Planning Assessment Report

Application to Modify the Minister's Approval for the Sydney Water Facility, Potts Hill Reservoirs Site

Major Project 08_0049 MOD 1

Roof Plan

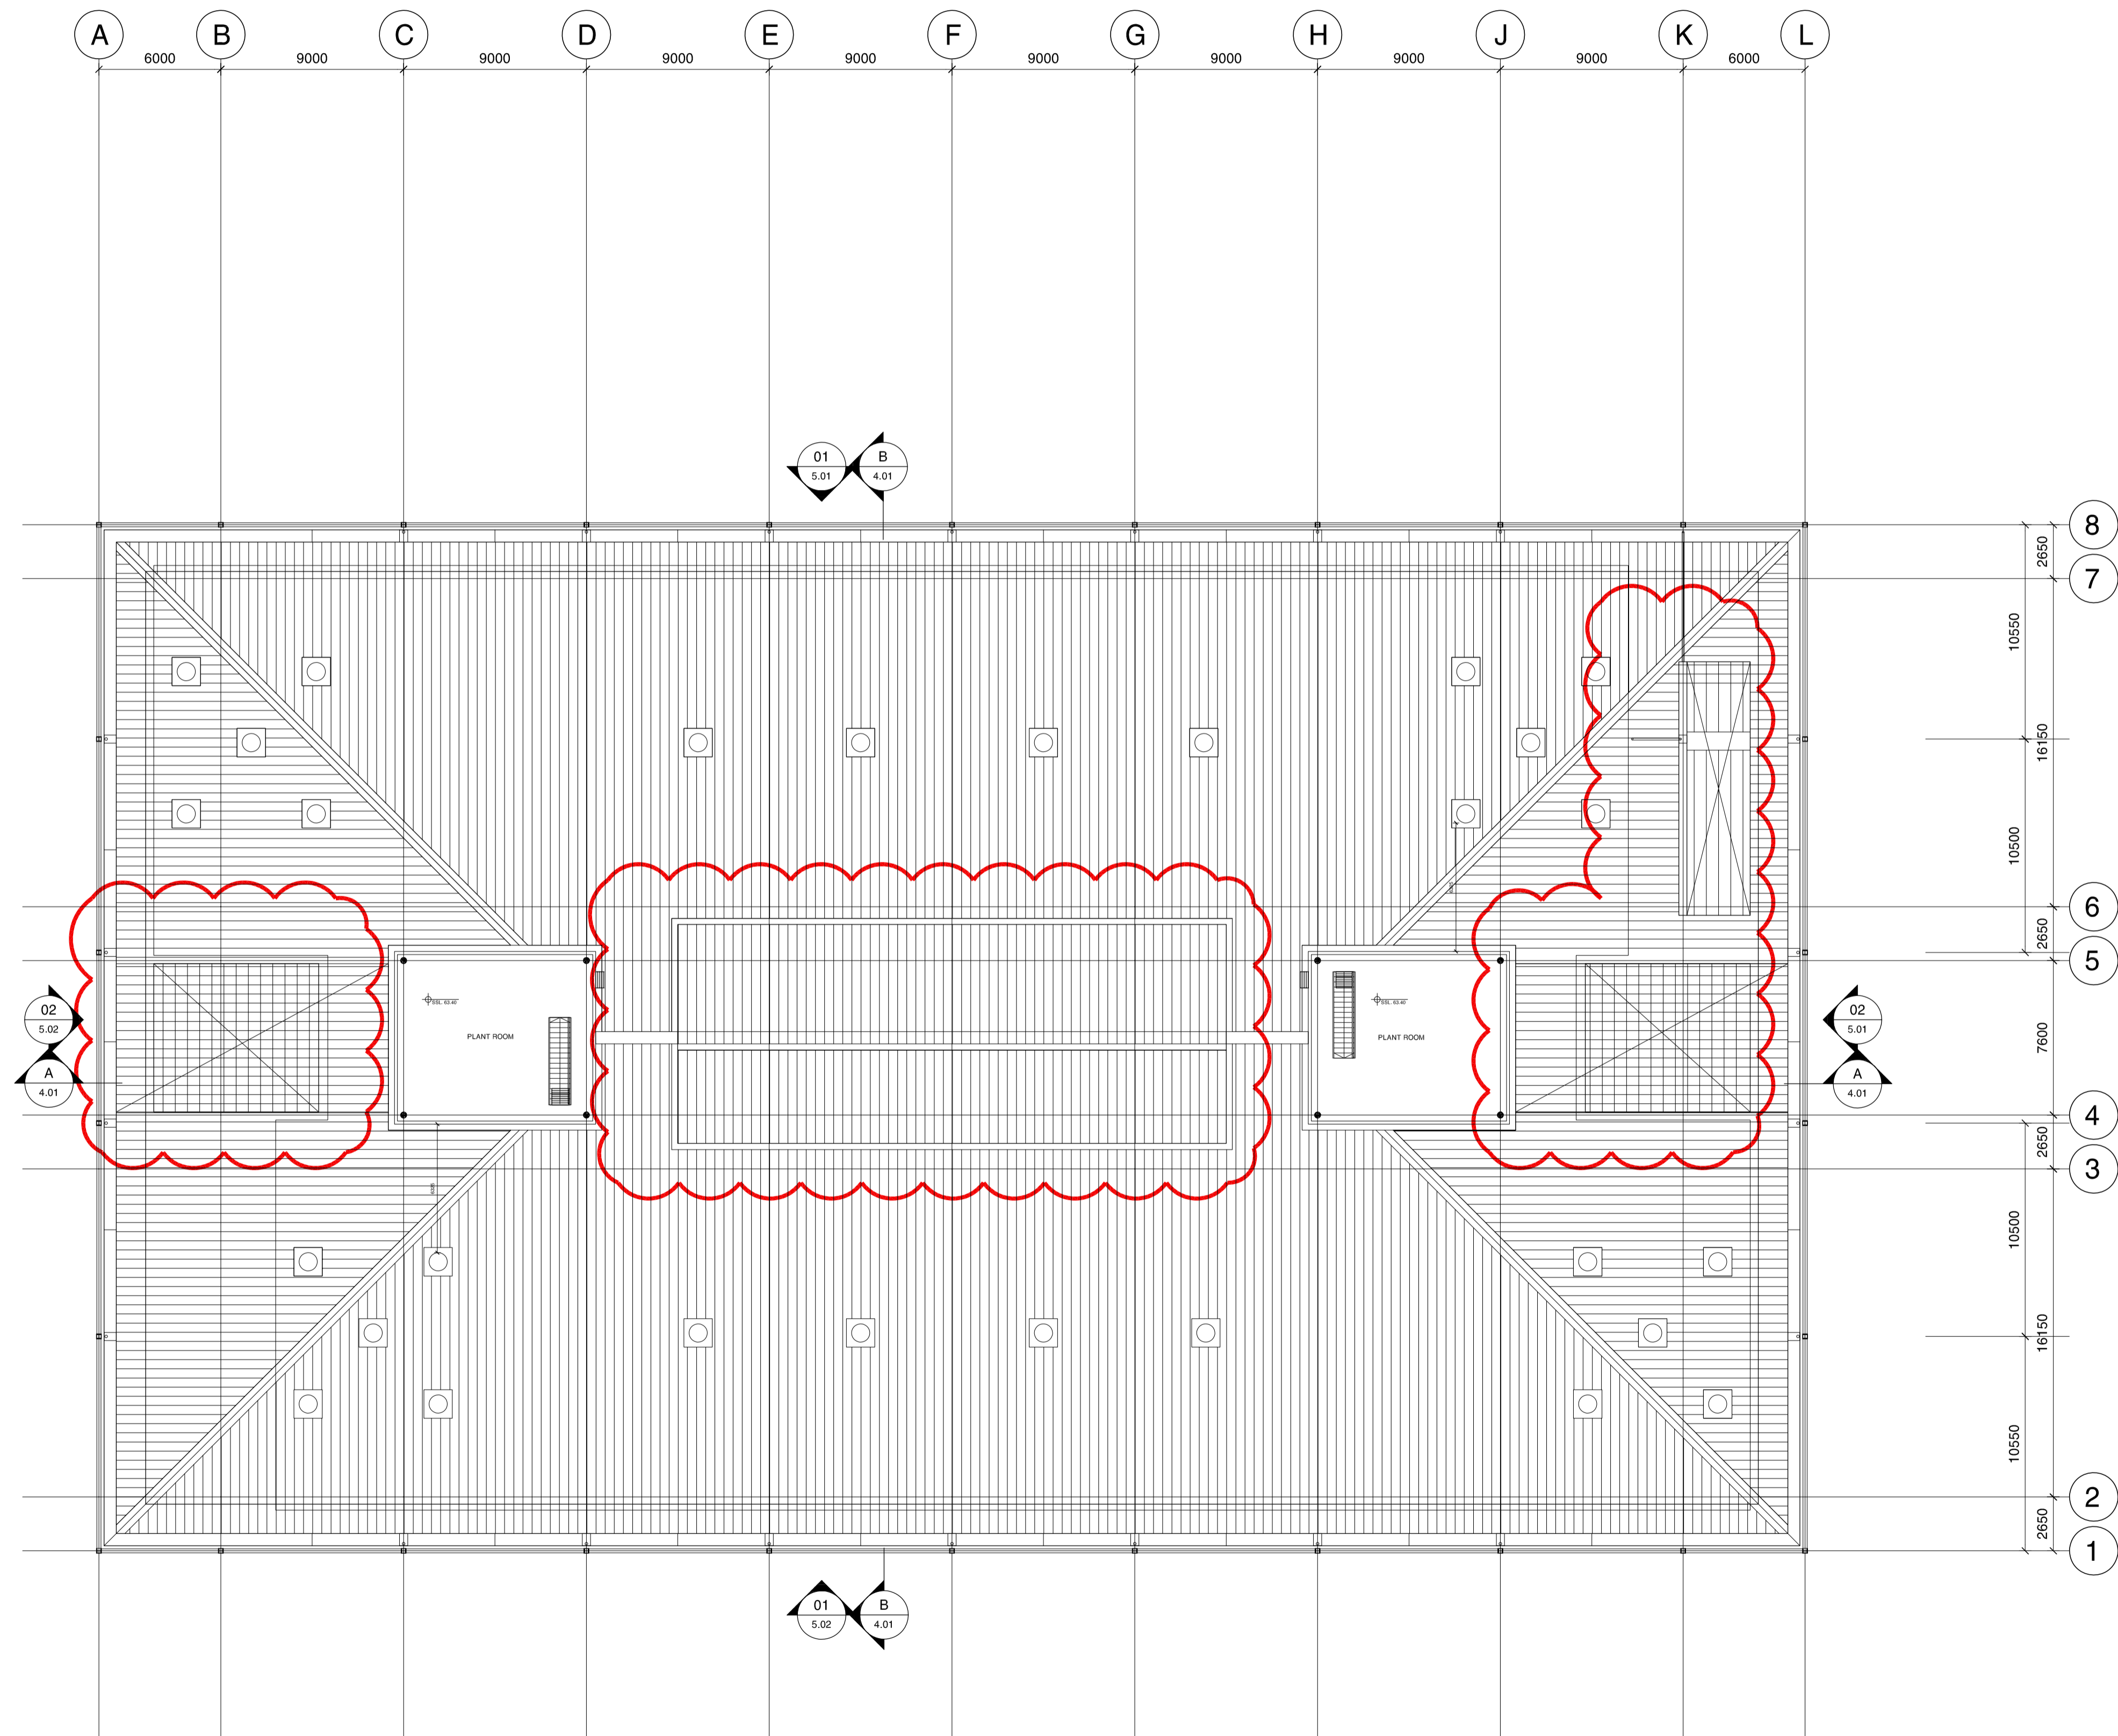
With regard to the main office, the atrium/vent design has changed from a butterfly configuration to a south opening saw tooth configuration. This is a consequence of more detailed design work which concluded that the new design provide for improved internal comfort levels and energy efficiency by reducing direct sunlight entering the building and the heat load that accompanied it during the warmer months. Visually, it is considered to be a minor change to the form of the roof line that will not alter the general architectural style. The width of the structure has also been reduced corresponding to the reduction in width of the central bay of the building. Considering its central location on the roof, these changes in form and size will have minimal effect on the appearance.

- Entire building moved east by 1.2m.
- North segment extended east and south segment extended west by 3m.
- Central bay width decreased by 0.5m.
- Internal layout amendments.
- Minor floor level changes.
- Roof design amended and roof eaves level increased by 50mm.
